Application no: 23/01493/REM

Location: Proposed Himley Village North West Bicester, Middleton Stoney Road, Bicester

Transport Schedule

TITLE  
**S278 OFFSITE HIGHWAY WORKS  
PEDESTRIAN/CYCLE LINK  
GENERAL ARRANGEMENT  
SHEET 3**

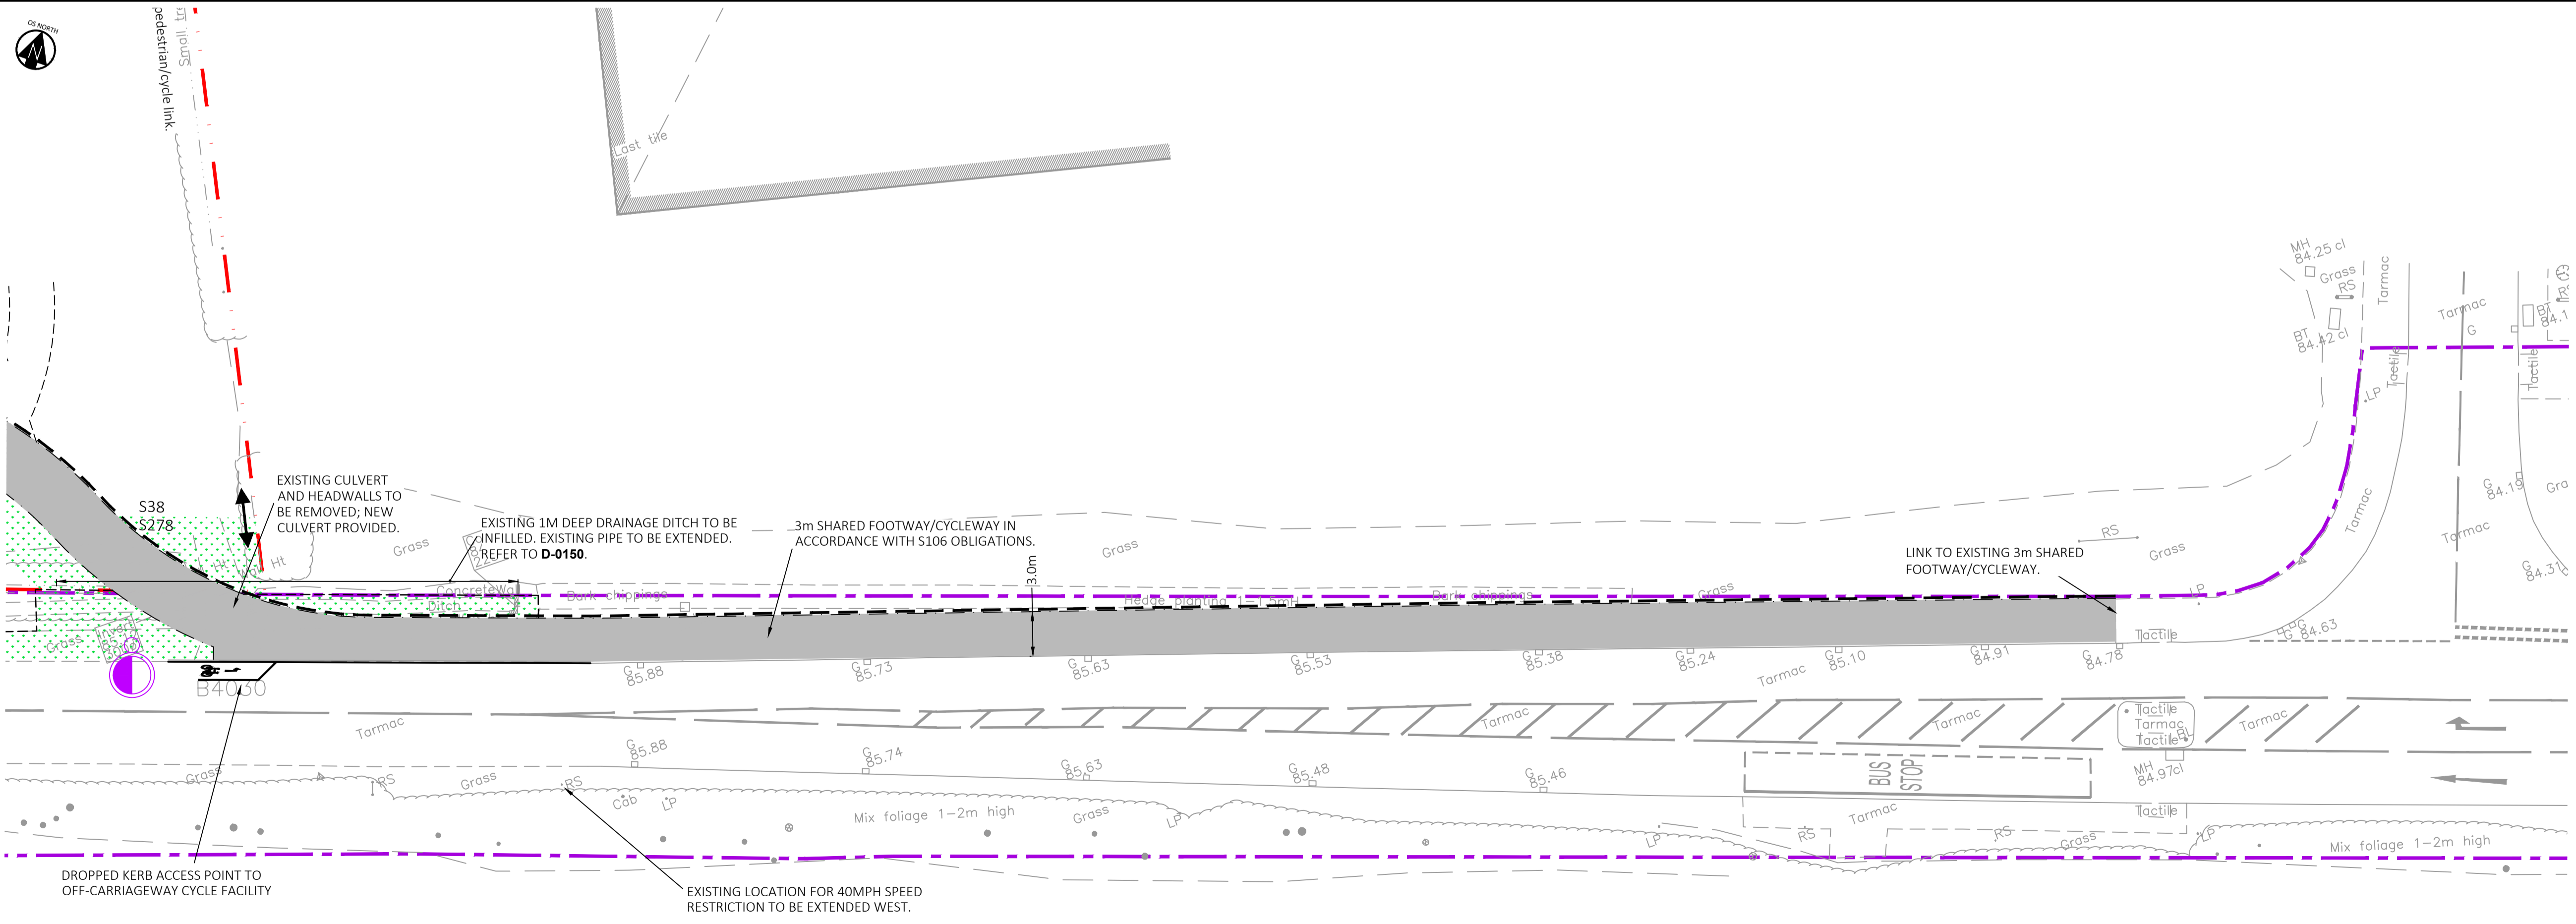
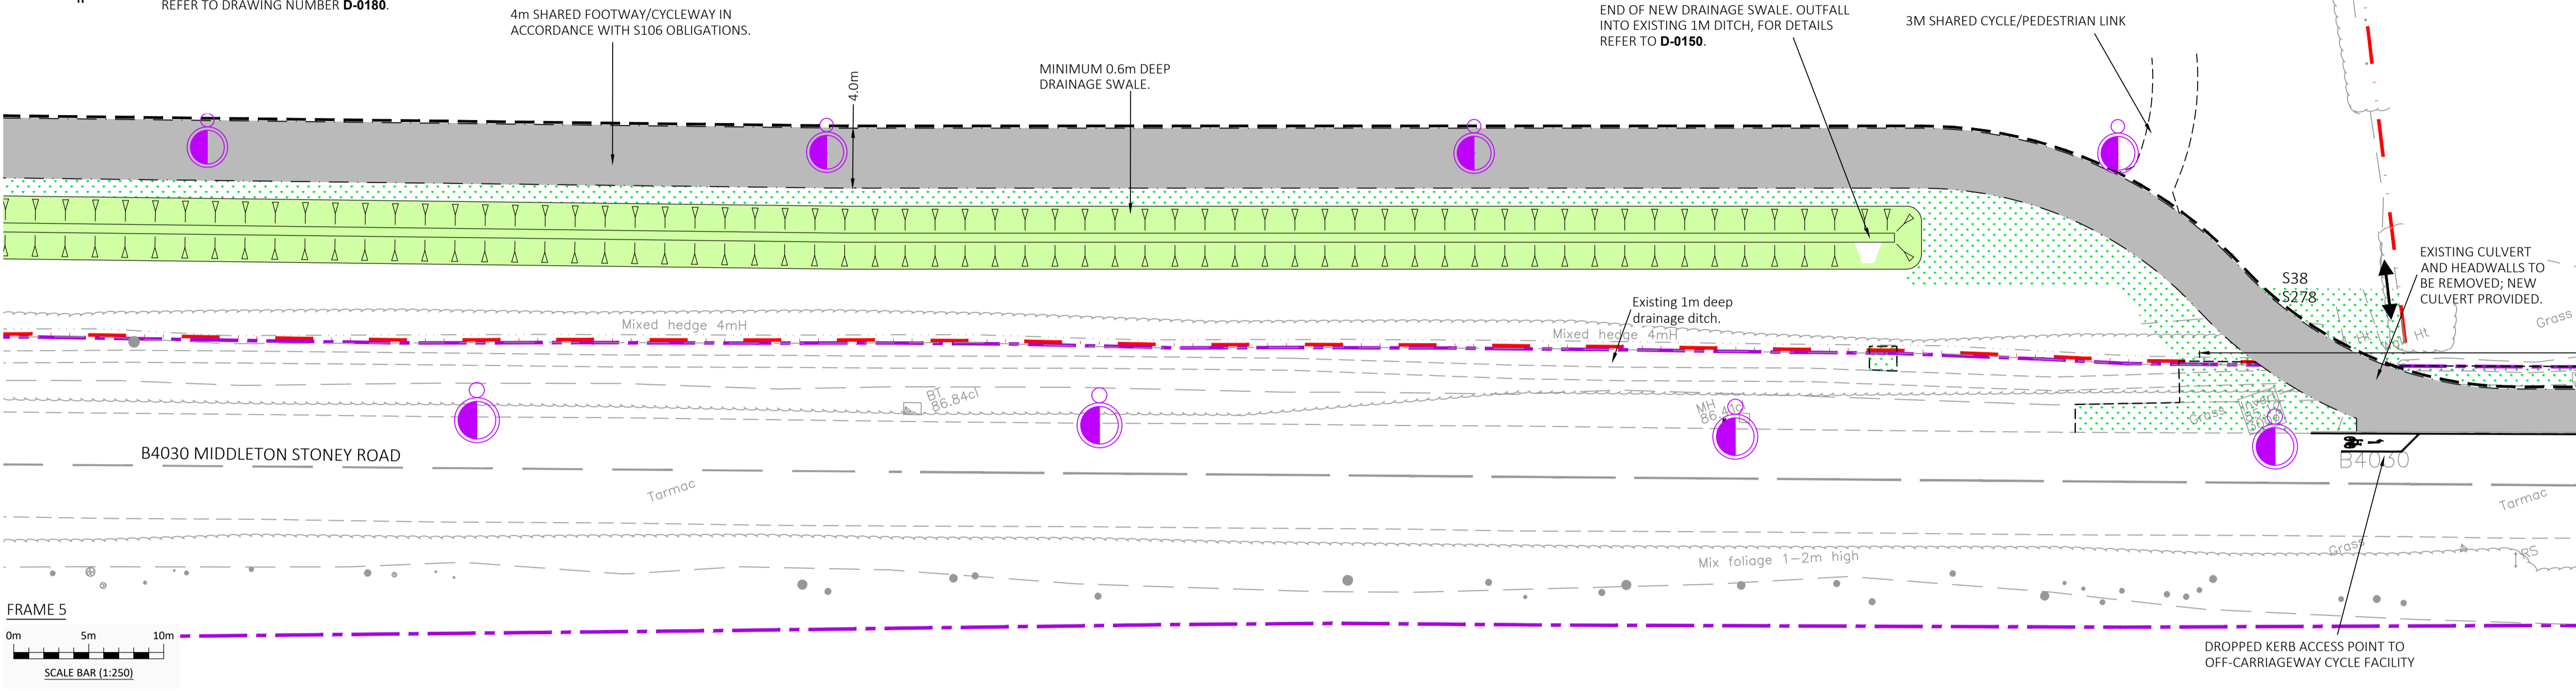
Width of this track is not clear - Design Code says 4m wide - please clarify.
